STATE OF WASHINGTON
DEPARTMENT OF ECOLOGY

March 28, 2014

Re: CU-13-00008

Thank you for the opportunity to comment on the notice of application for the conditional use permit for an electrical substation on 52 acres, proposed by Central Washington University. We have reviewed the application and have the following comment.

**HELENA AVENUE SUBSTATION**  
 SITE PLAN OVERVIEW  
 CITY OF ELLENSBURG  
 501 NORTH ANDERSON STREET  
 ELLENSBURG, WA 98926

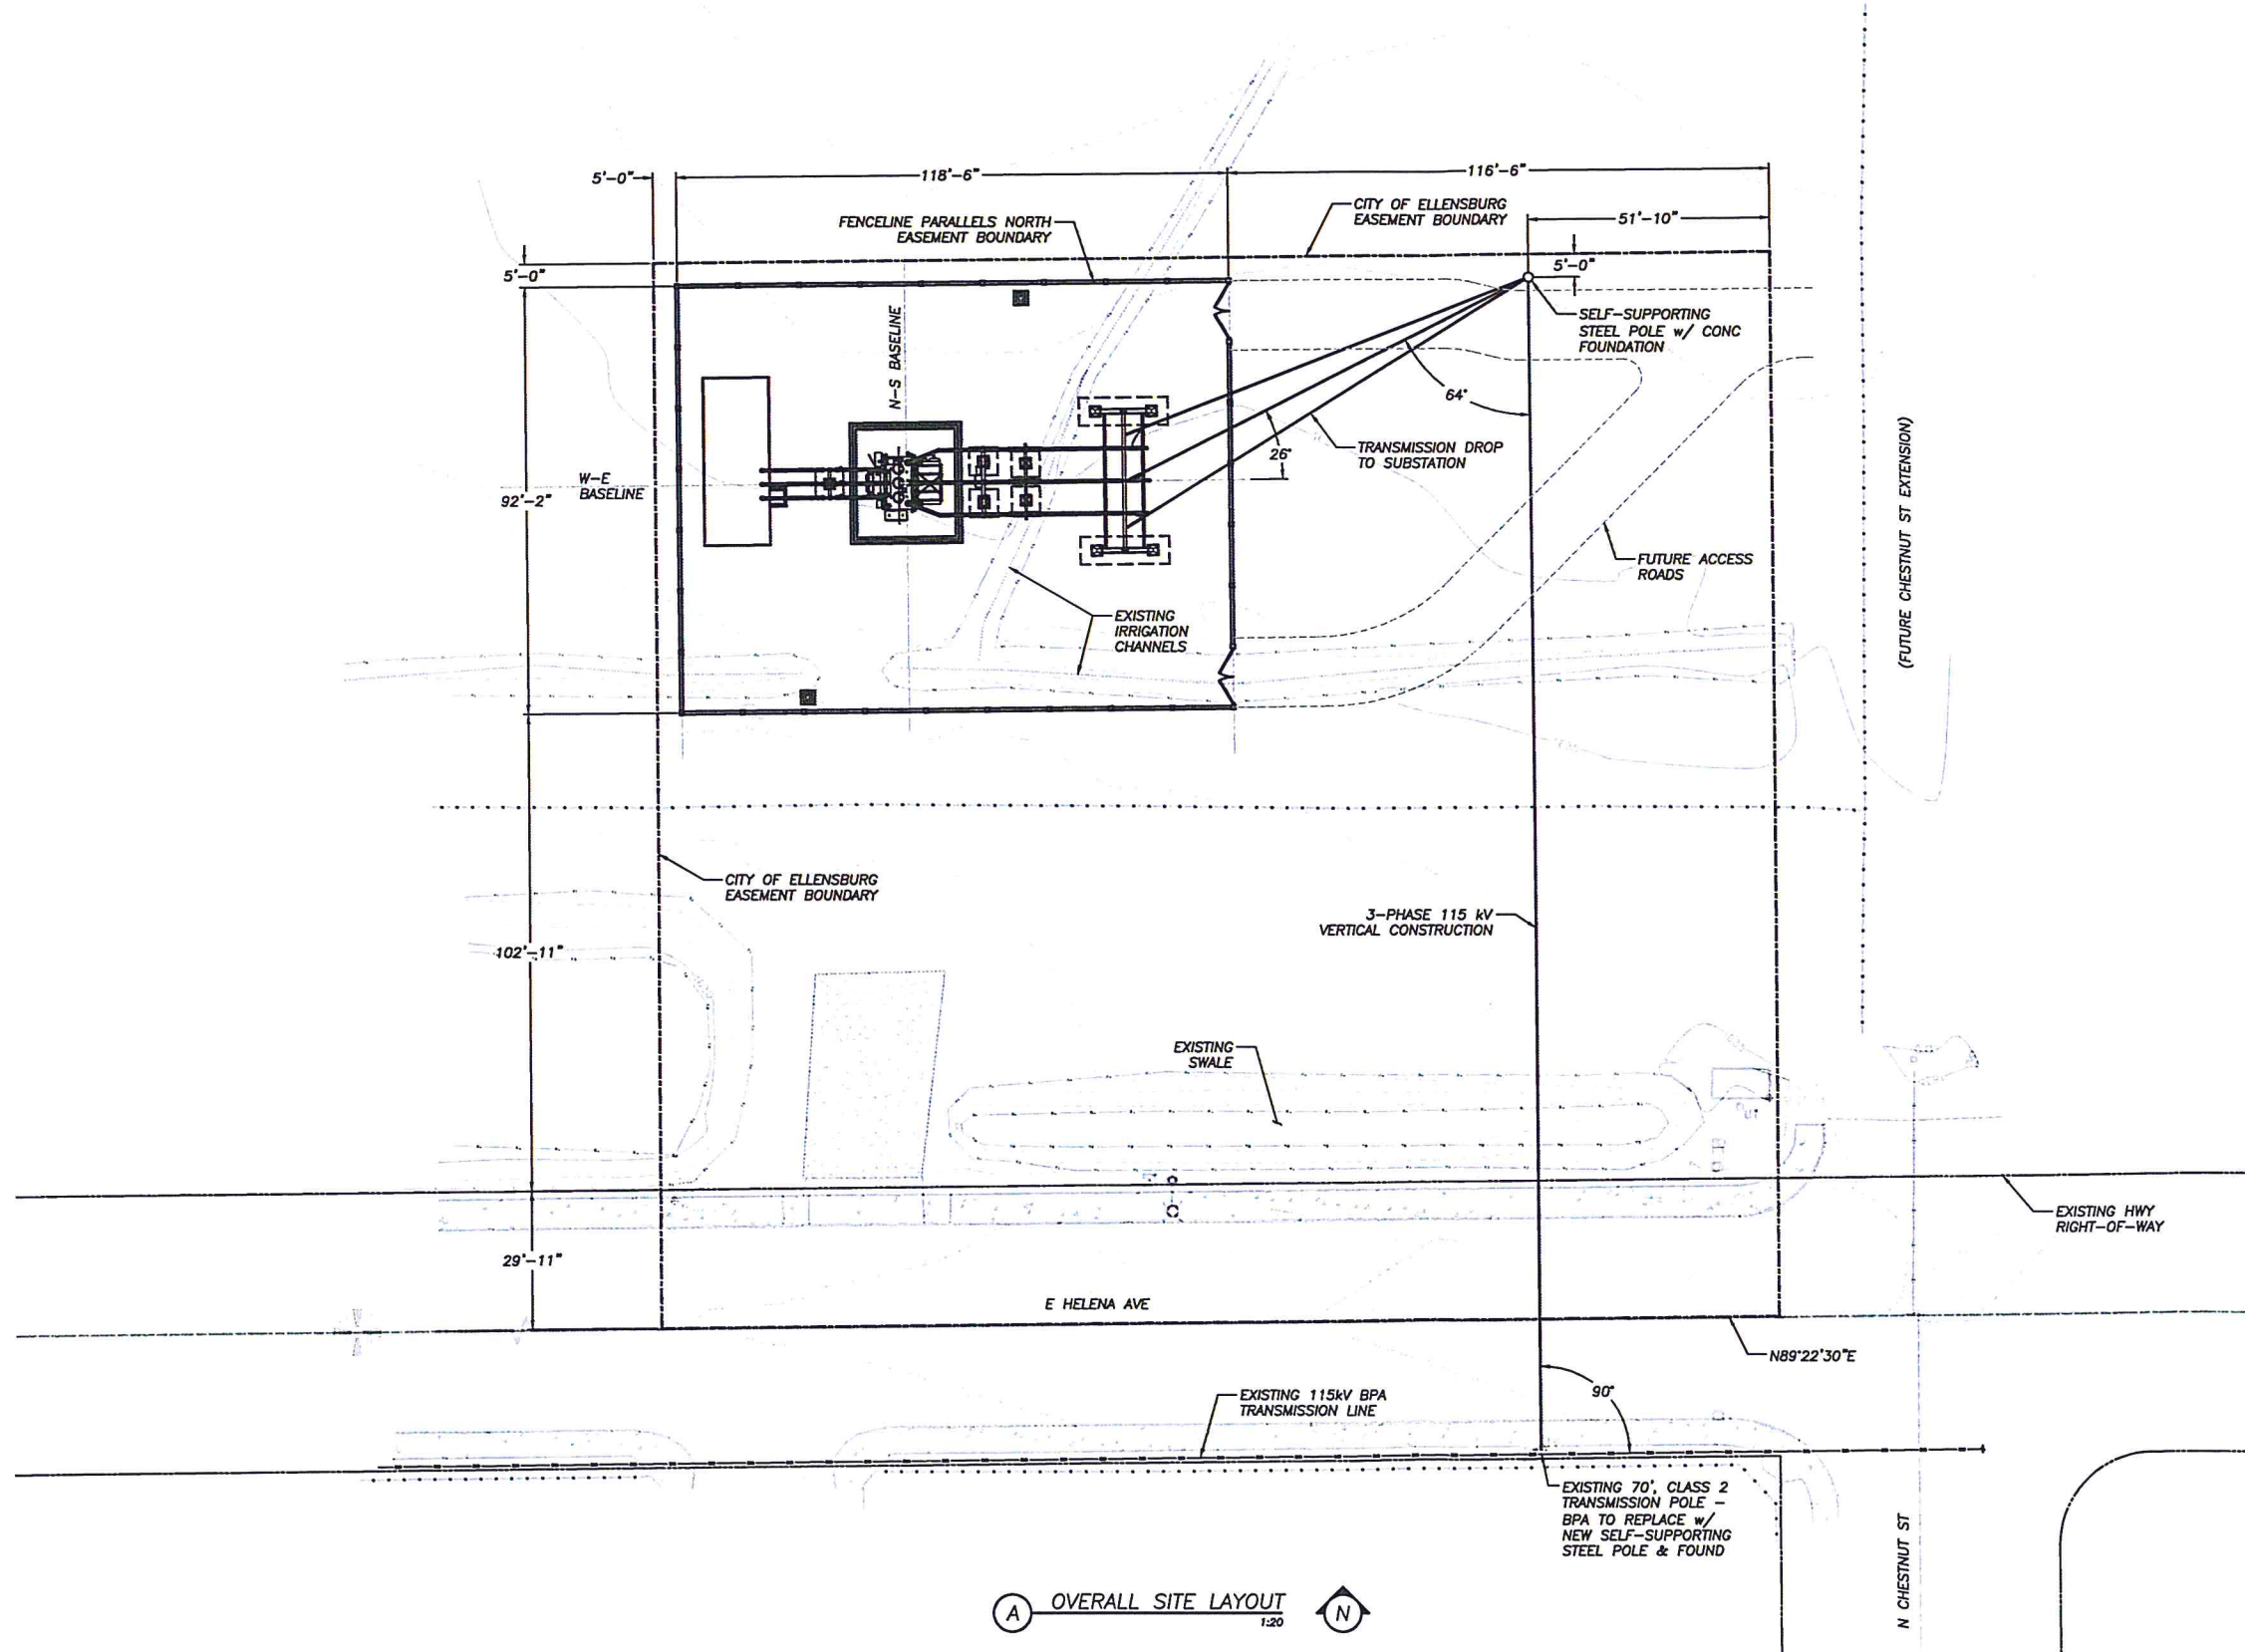
Mention is made in sent documents regarding the presence of an infiltration swale along the southwest corner of the site. SEPA information should include a plan and cross section of this swale. If the swale would be placed in a wetland area, wetland mitigation may be required.
